CITY OF ALBUQUERQUE

February 10, 2020

**Re: Monterey Place Apartments – 2306 Central Ave SW
Erosion Sediment Control Plan
Engineer's Stamp Date 12/13/19 (J12E030)**

STABILIZED CONSTRUCTION ENTRANCE

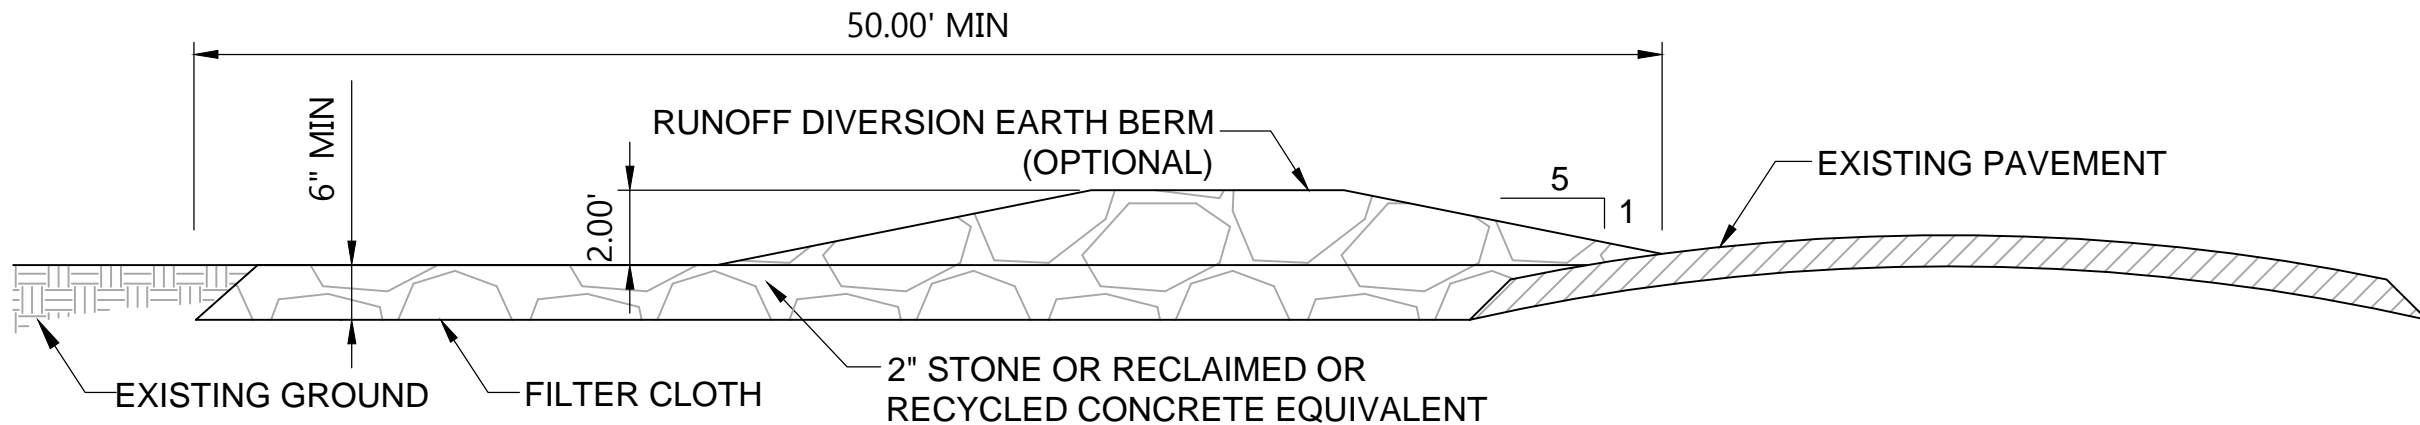
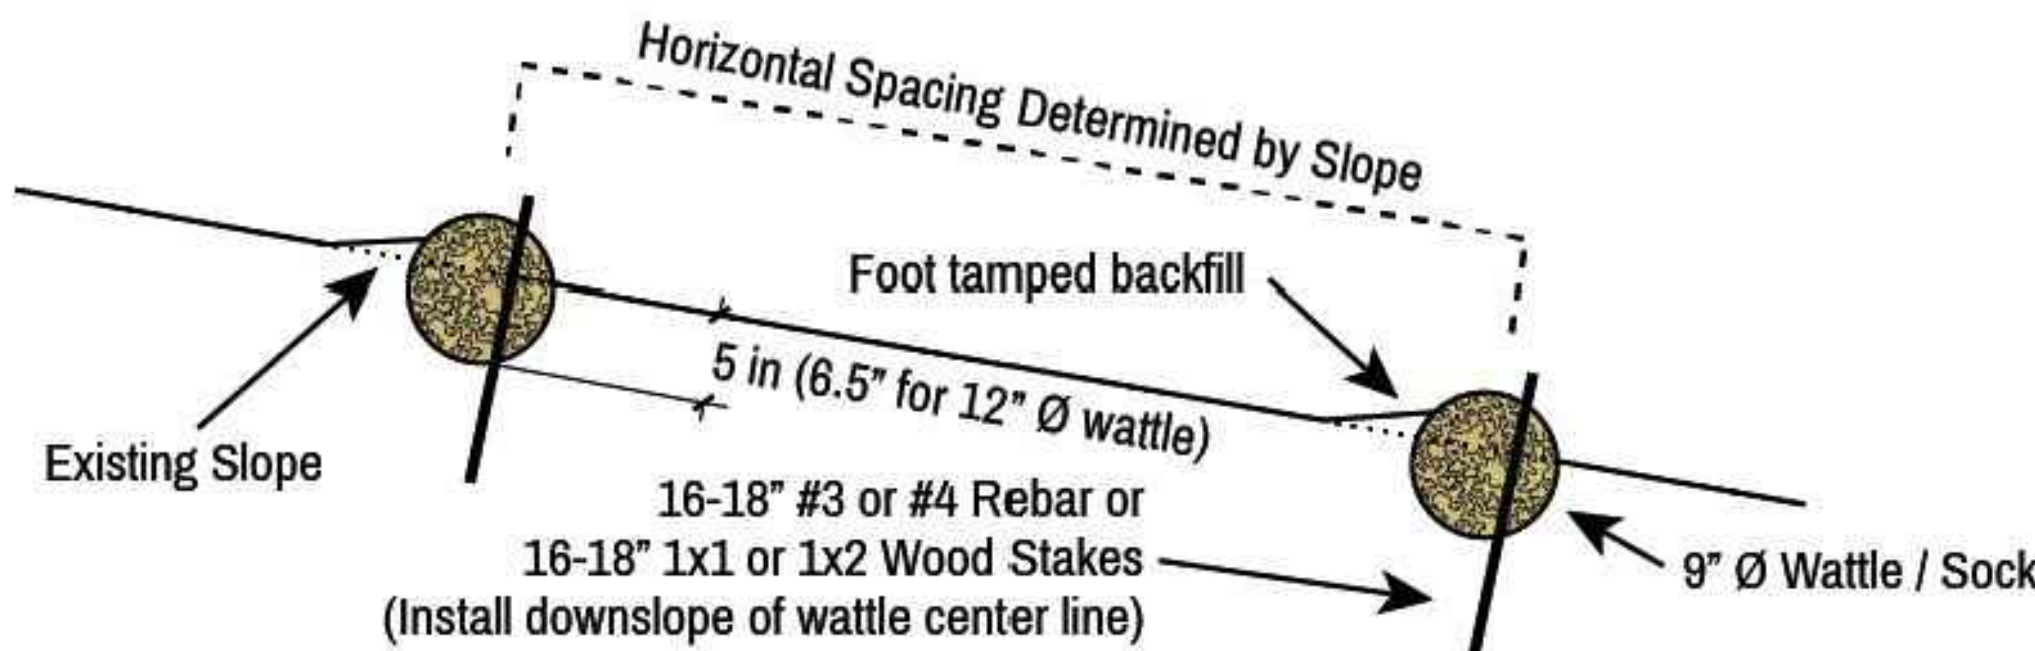
3. The plan must be at a standard engineering scale with a graphic scale bar on the plan.
4. The last note on the construction entrance detail regarding sweeping is inconsistent with the CGP. Replace this note with the actual wording of the CGP 2.2.4.

EROSION CONTROL PLAN - MONTEREY PLACE APARTMENTS

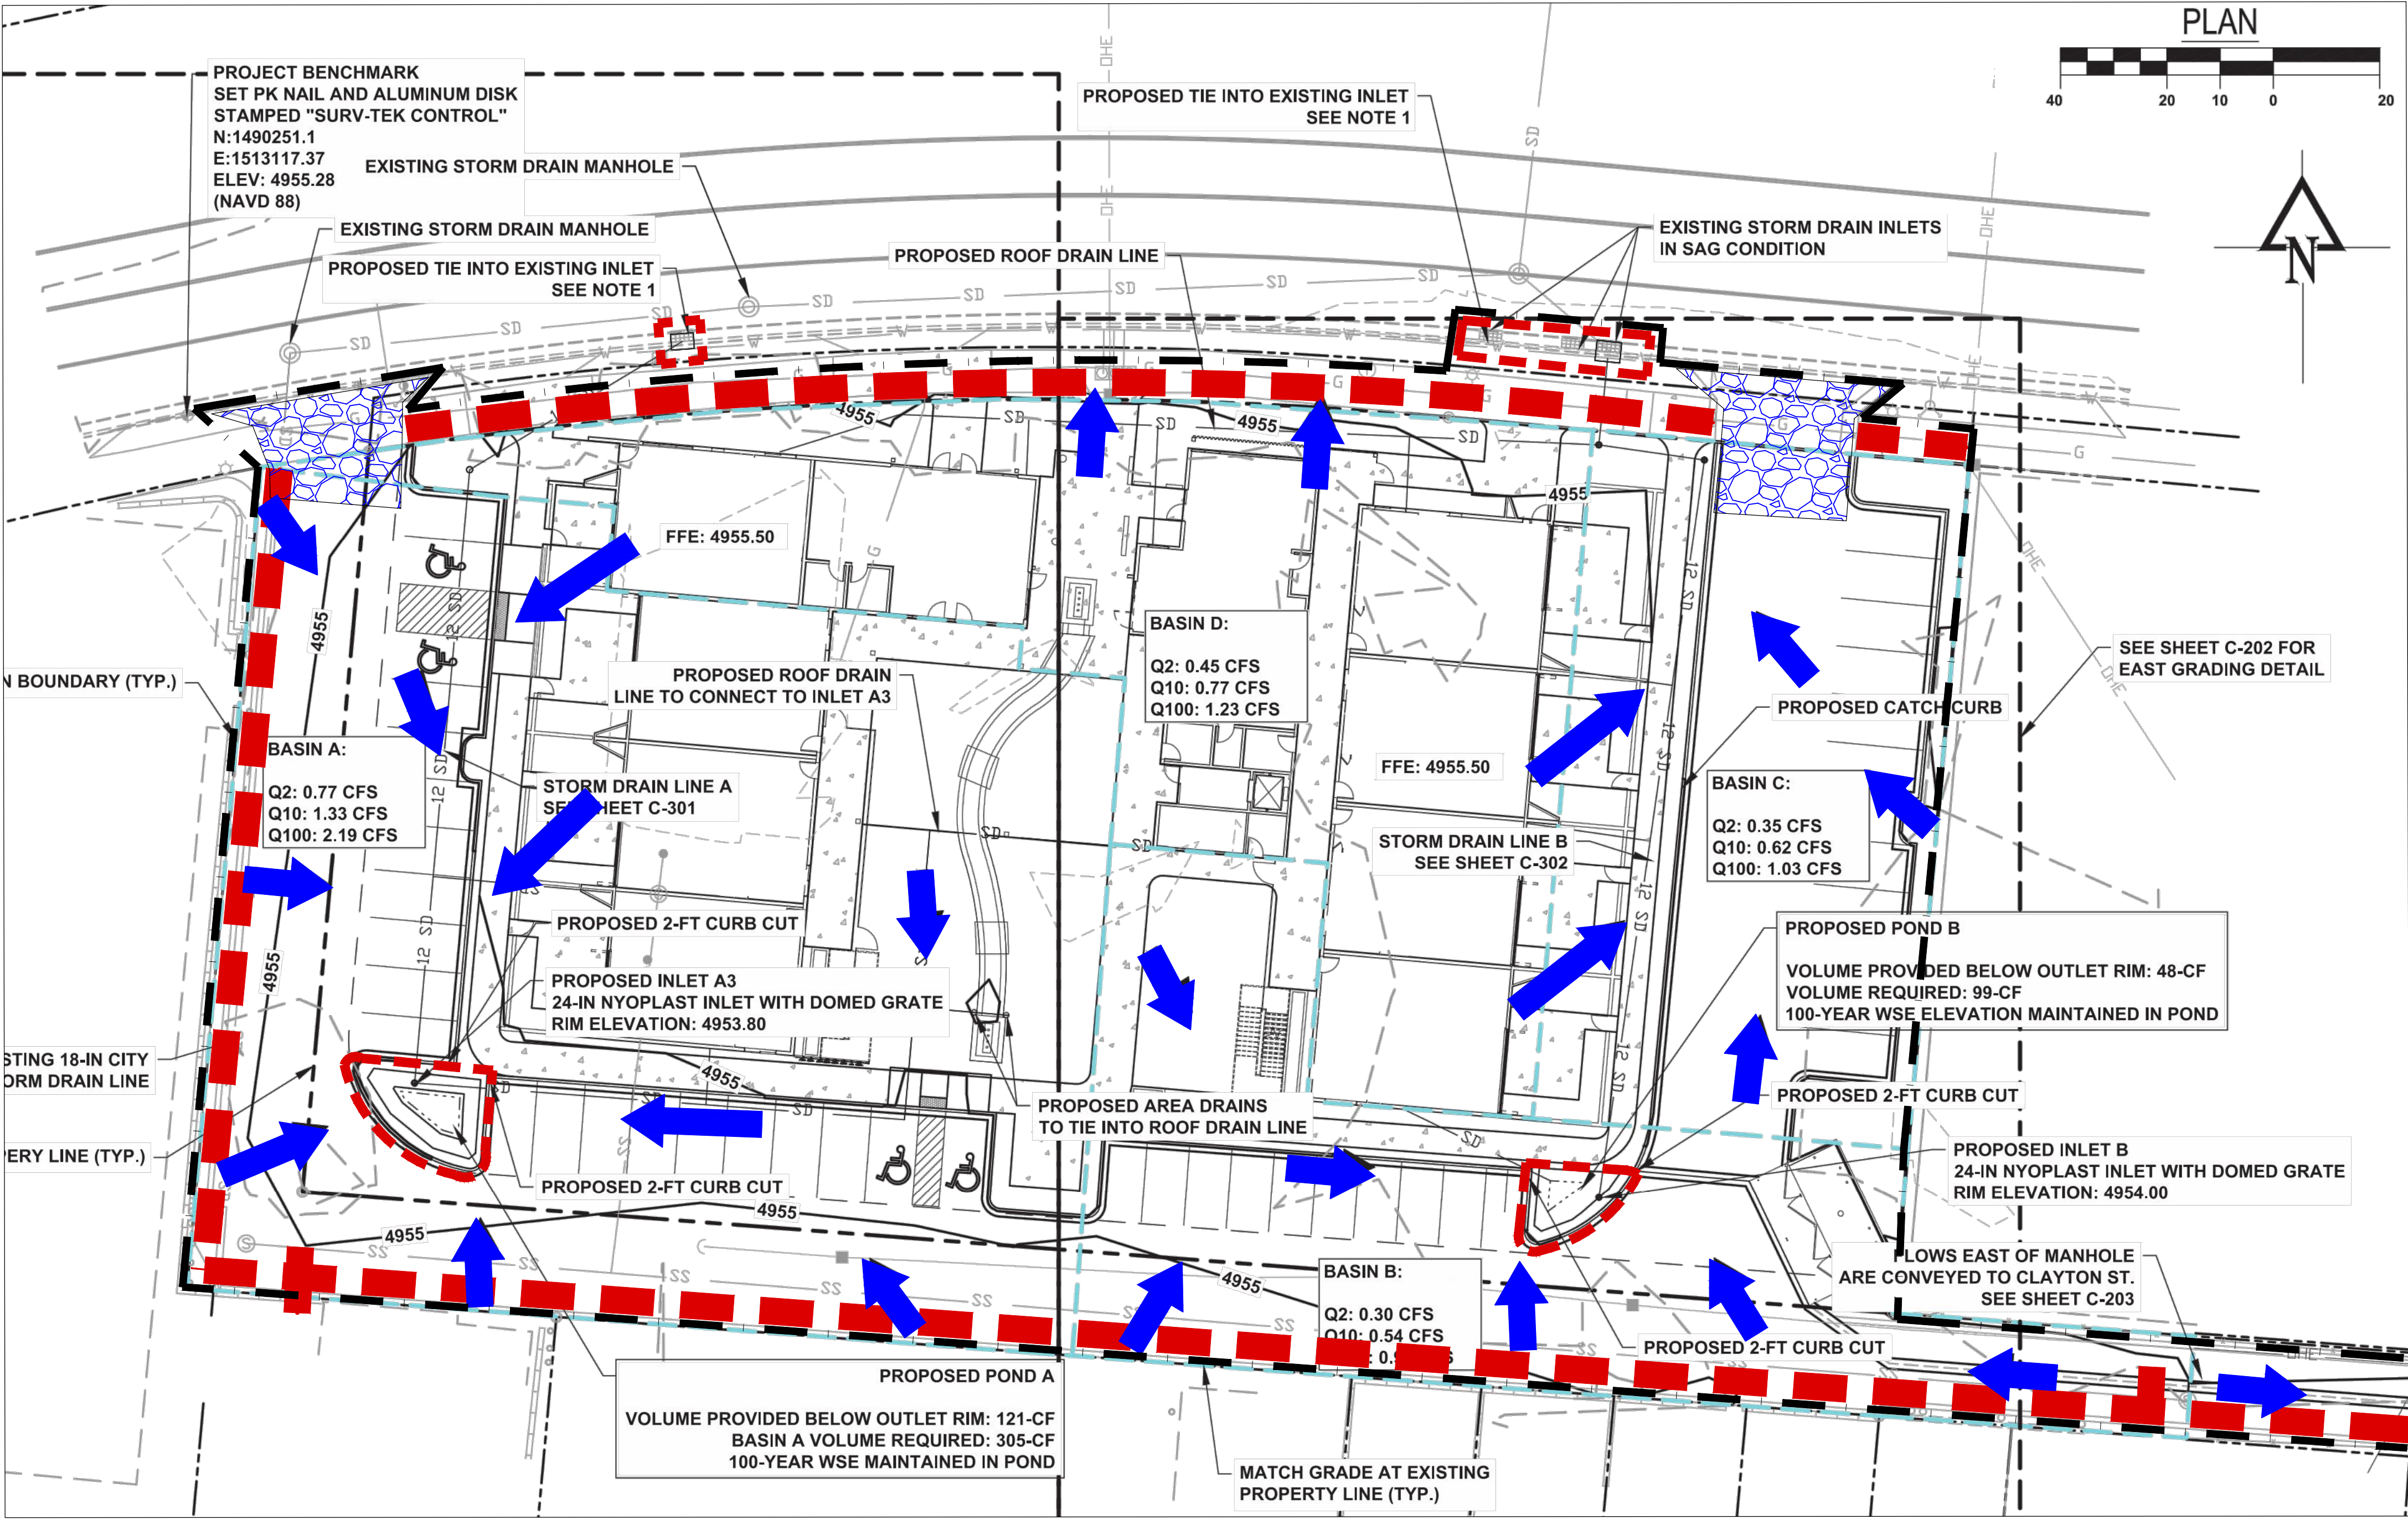
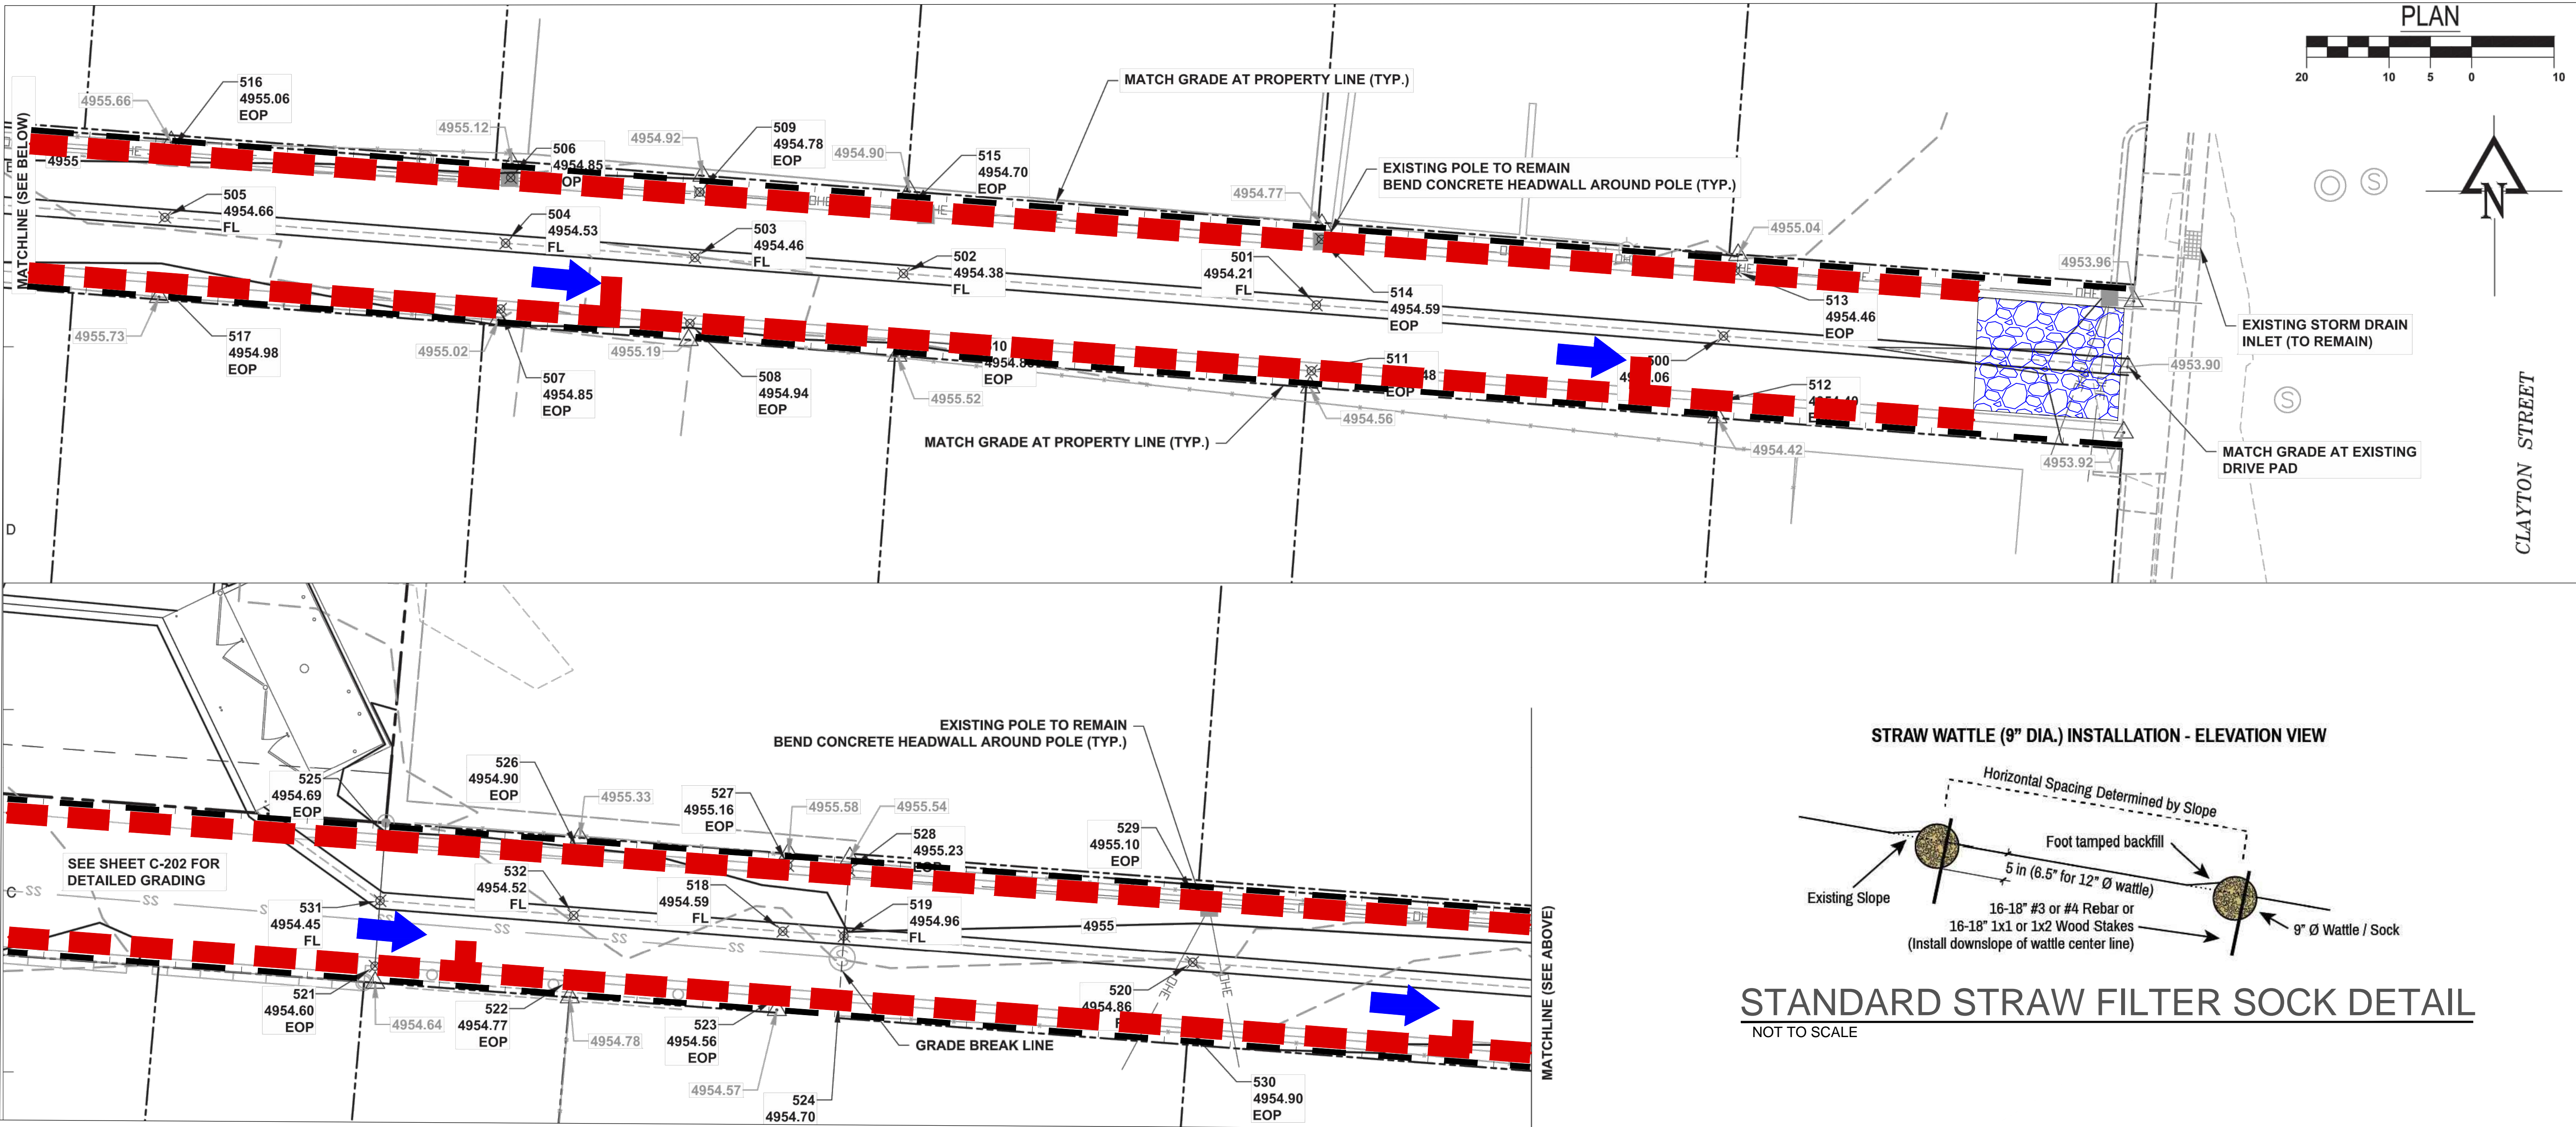
1. The wording of Erosion Control Note # 3 is inconsistent with the criteria in CGP 2.2.14.b. and should be deleted. The 70% criteria refers only to the portion of the site not covered by structures, and further refers to the minimum density of permanent vegetation where only vegetation is used. It also says there should not be any large bare areas. City standard notes 3 and 4 address the issue of final stabilization (see below).

2. The limits of disturbance must be indicated on the plan and in the legend. Allow for removal of the existing driveways and sidewalks at the storm drain connections to the existing inlets.

5. Please add a note stating that "The ponds will be the first item of earthwork construction and will be maintained as a temporary sediment traps during construction".
